DEVELOPMENT REVIEW BOARD – SPEED MEMO

DRB CASE NO/PROJECT NO: 1003467

Sketch Plat

RE: Tract 11-A, 11-B, 11-C, Rice Duranes Addition/sketch

DISCLOSURE STATEMENT

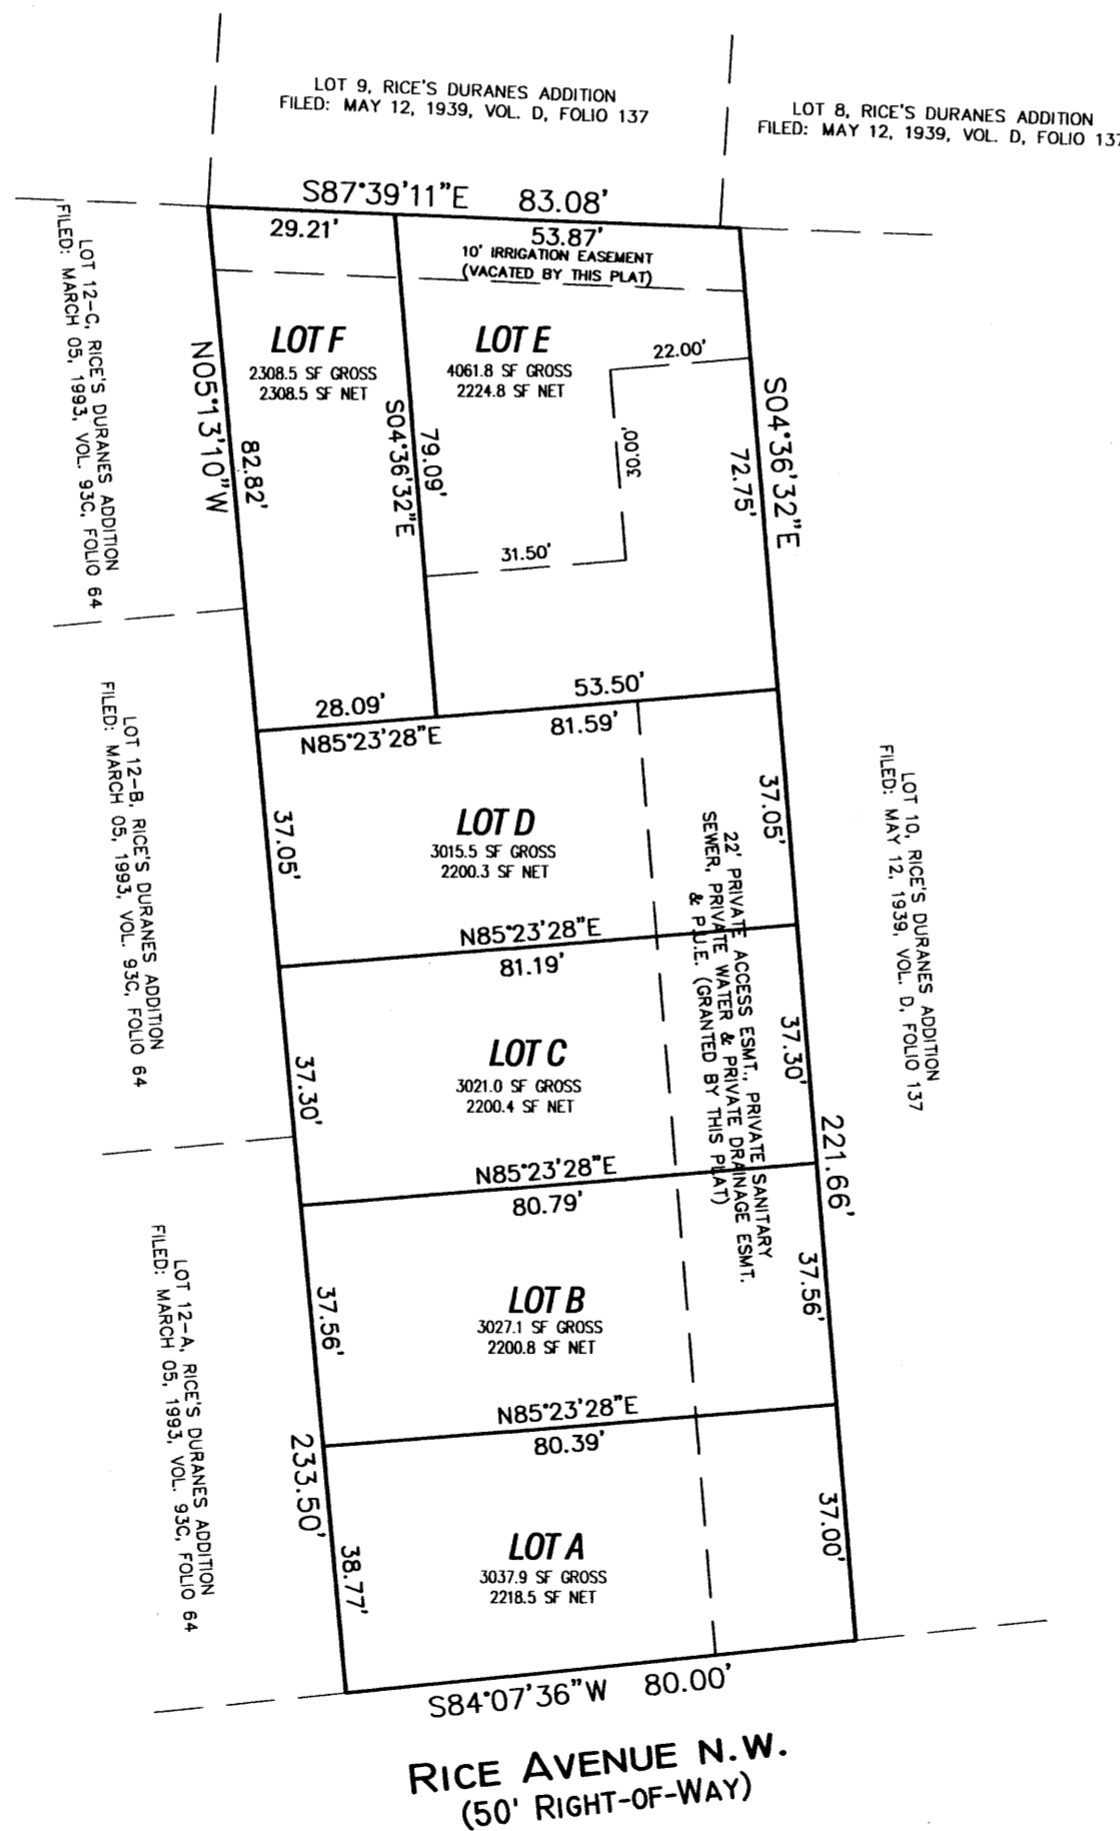
An approved grading and drainage plan must be on file prior to Preliminary Plat approval.
Vacation of ditch easement must be approved by the MRGCD.
Infrastructure List will be required

- 1) Access for 6 lots requires a 32' easement. (Single loaded - 24' of graveled road with a 4' sidewalk)
- 2) A cross-section of Rice Ave. is needed to determine if any dedication or infrastructure is required.
- 3) Standard infrastructure per DPM is required.
